From: David Elmore
Sent: 21 November 2022 12:30
To: Validation (Shared Mailbox)
Subject: FW: Former Beales Hotel (ref: 6/2022/1355/MAJ) - LLFA Response
Attachments: Thames Water email.pdf

From: Rose Adams [REDACTED]
Sent: 17 November 2022 16:24
To: FRMConsultations [REDACTED]
Cc: David Elmore <d.elmore@welhat.gov.uk>; David Uncle <david.uncle@hertfordshire.gov.uk>; Mark Westcott [REDACTED] Bridget Miller [REDACTED]
Subject: Former Beales Hotel (ref: 6/2022/1355/MAJ) - LLFA Response

Thank you for providing your response to the Former Beales Hotel application (ref: 6/2022/1355/MAJ) on the 2nd November (attached).

drawing: General Arrangement
 Proposed Seventh Floor Plan

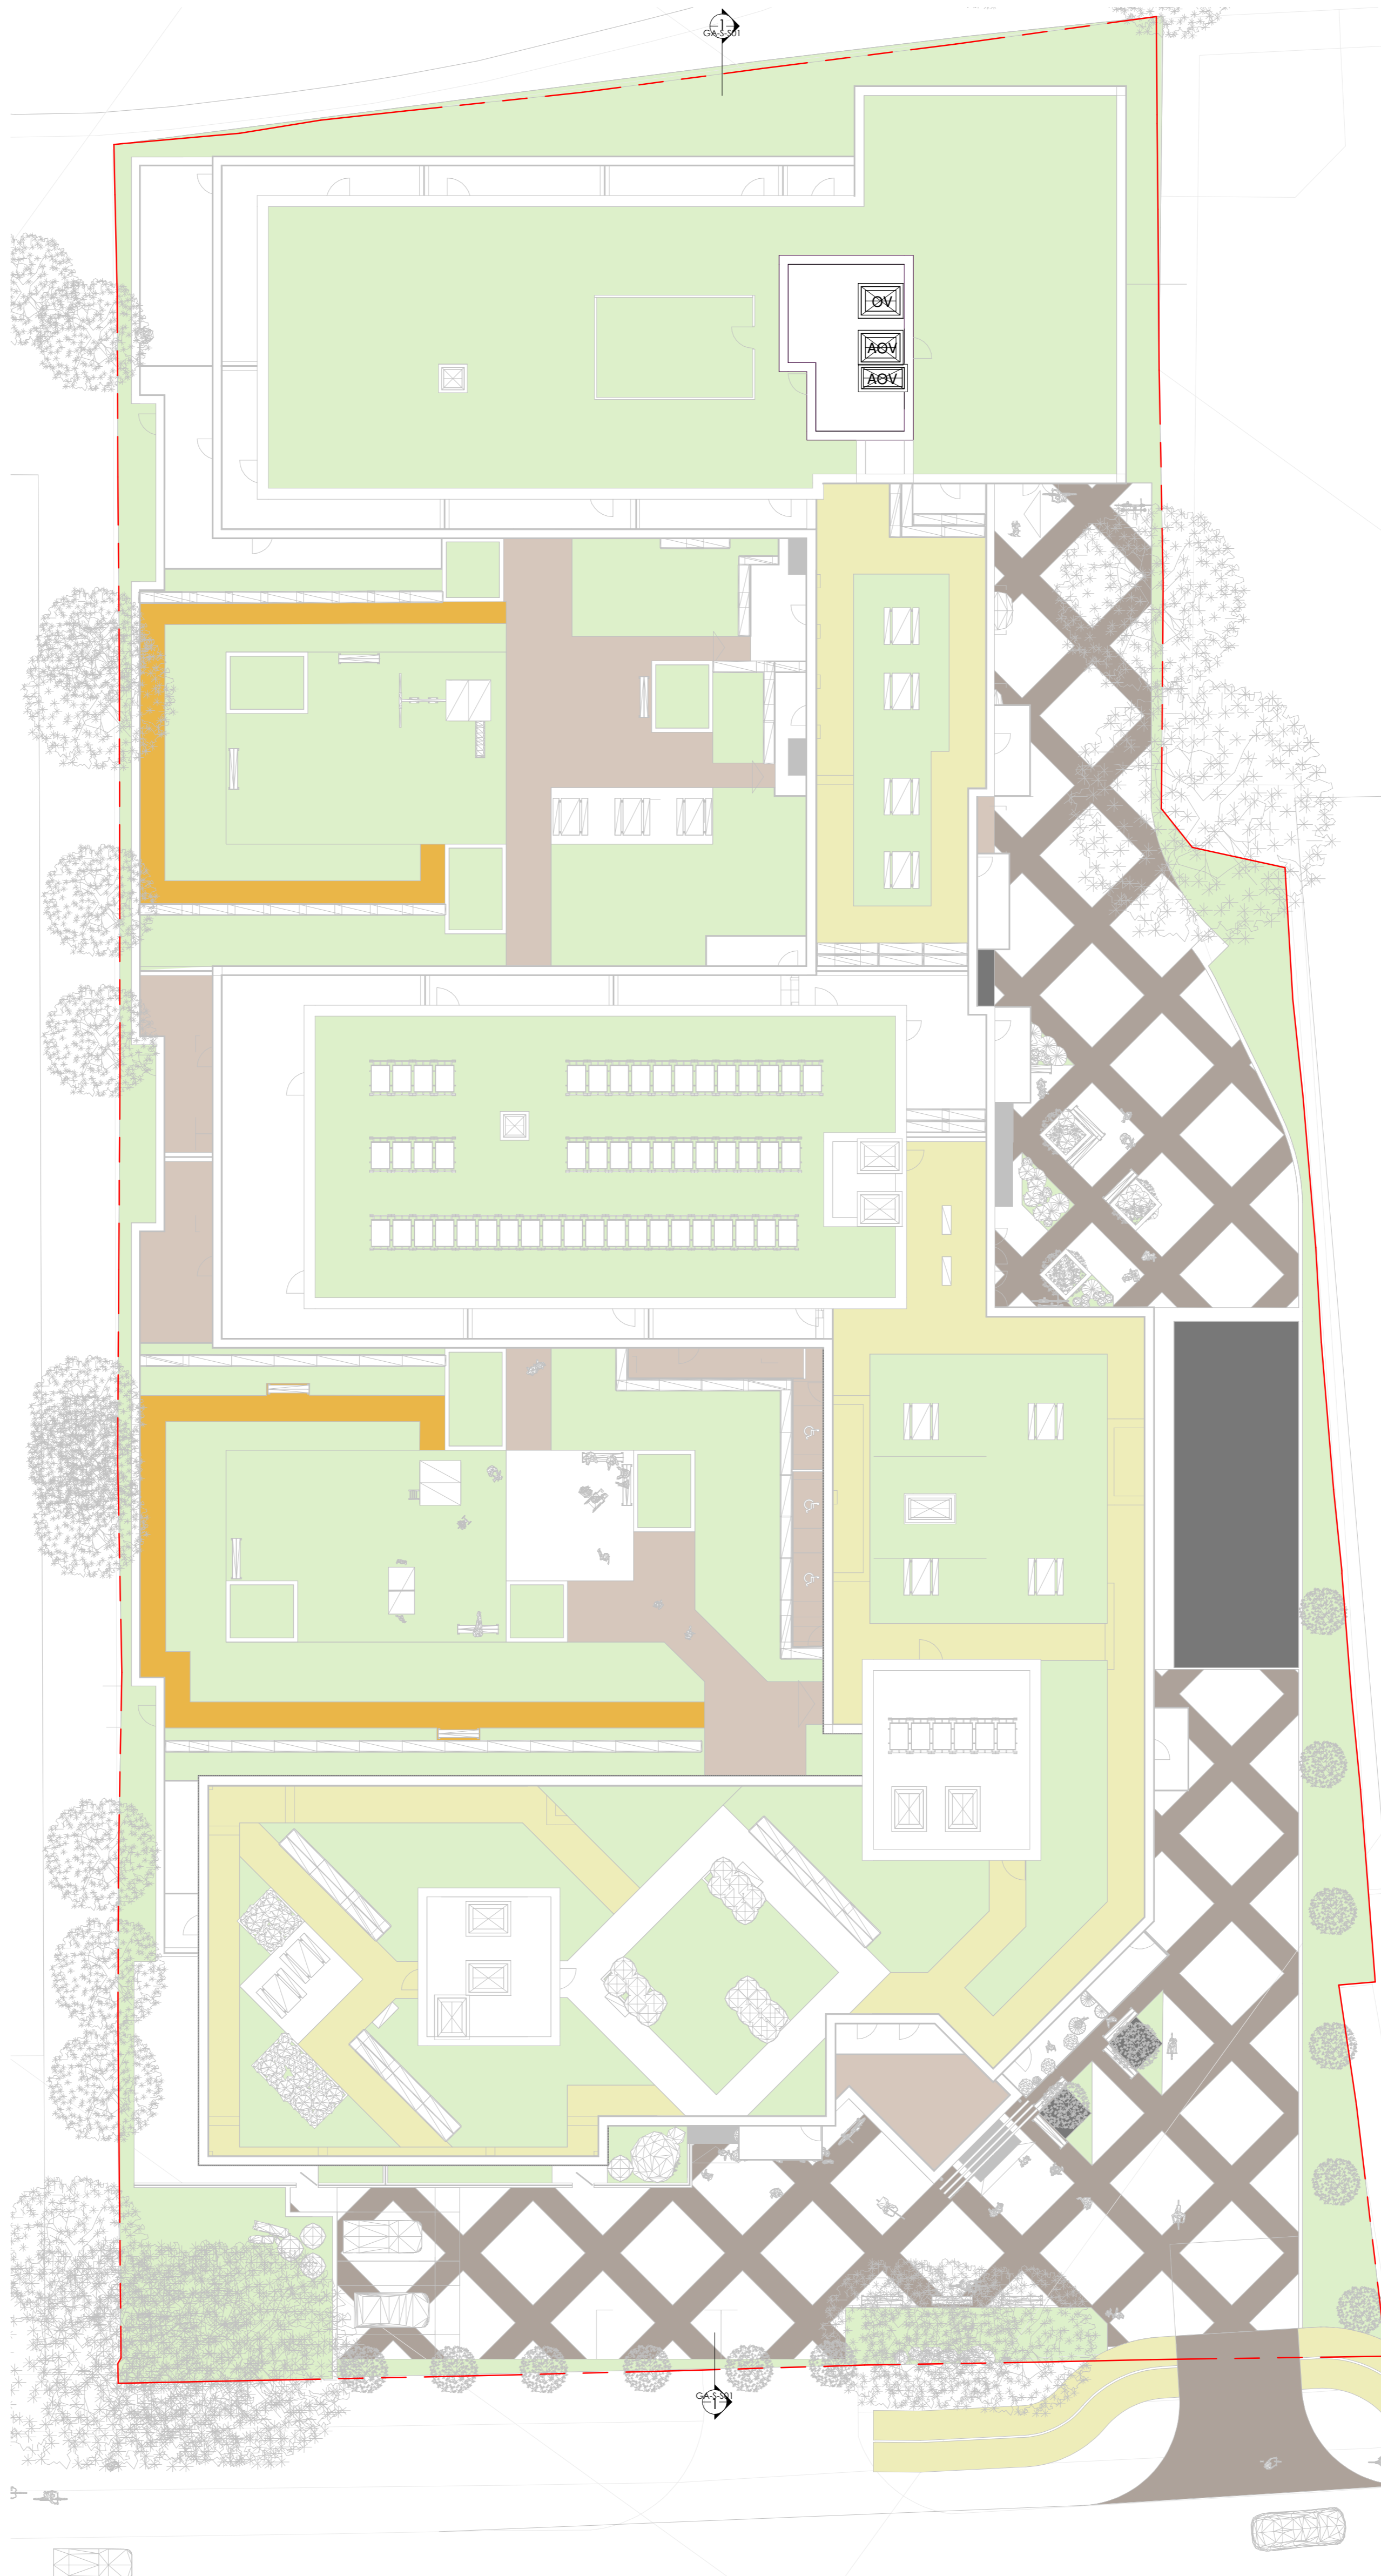
- With regards to green roof/blue roofs, section 5.18-5.22 in the submitted report discusses the green roof potential at the site on the 7th floor. A feature that is proposed to be integrated with PV panels.
